From: Paul Cann
Sent: 25 August 2017 12:46
To: Planning.Responses
Subject: RE: Planning Consultation on: LU/249/17/PL

APPLICATION LU/249/17/PL

Site Address: Directors Cottage Toddington Lane Littlehampton BN17 7PP

Description of Works: Demolition of the existing bungalow & redevelopment of the site with 5 No. detached houses. This application is a Departure from the Development Plan

Drawing: **LOCATION, STREET SCENE & EXTERNALS**

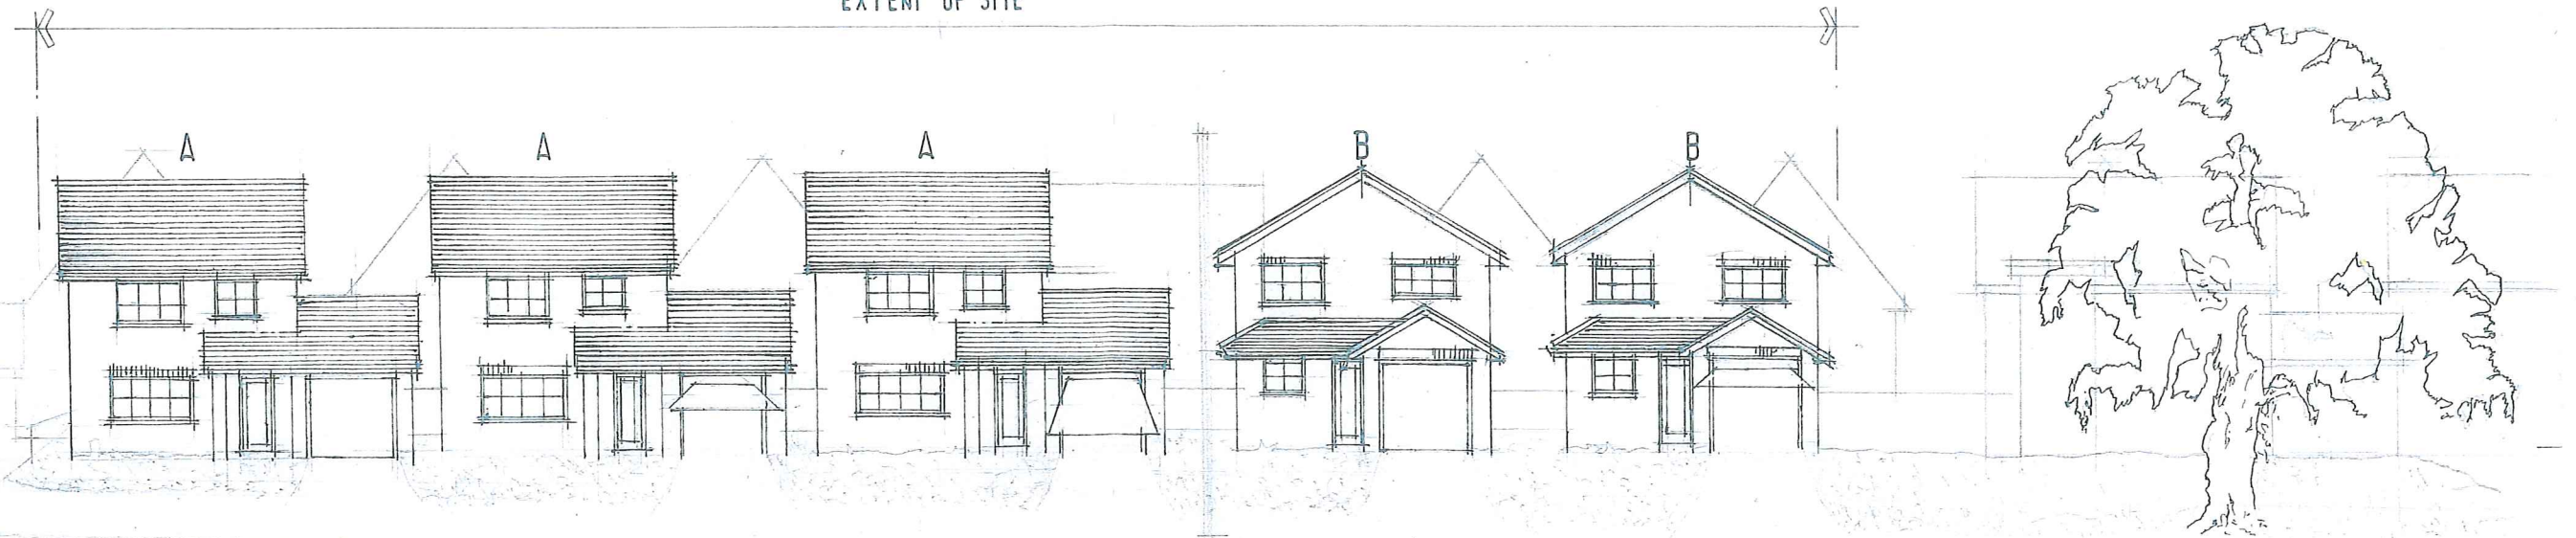
Soakaways must be investigated for surface water disposal.

Infiltration rates for soakage structures are to be based on percolation tests undertaken in the winter period and at the location and depth of the proposed structures. The percolation tests must be carried out in accordance with BRE 365, CIRIA R156 or a similar approved method and cater for the 1 in 10 year storm between the invert of the entry pipe to the soakaway, and the base of the structure. It must also have provision to ensure that there is capacity in the system to contain below ground level the 1 in 100 year event plus 30% on stored volumes, as an allowance for climate change. Adequate freeboard must be provided between the base of the soakaway structure and the highest recorded annual groundwater level identified in that location.

Any SuDS or soakaway design must include adequate groundwater monitoring data to determine the highest winter groundwater table in support of the design. The applicant is advised to discuss the extent of groundwater monitoring with the Council's Engineers. Supplementary guidance notes are also enclosed for information.
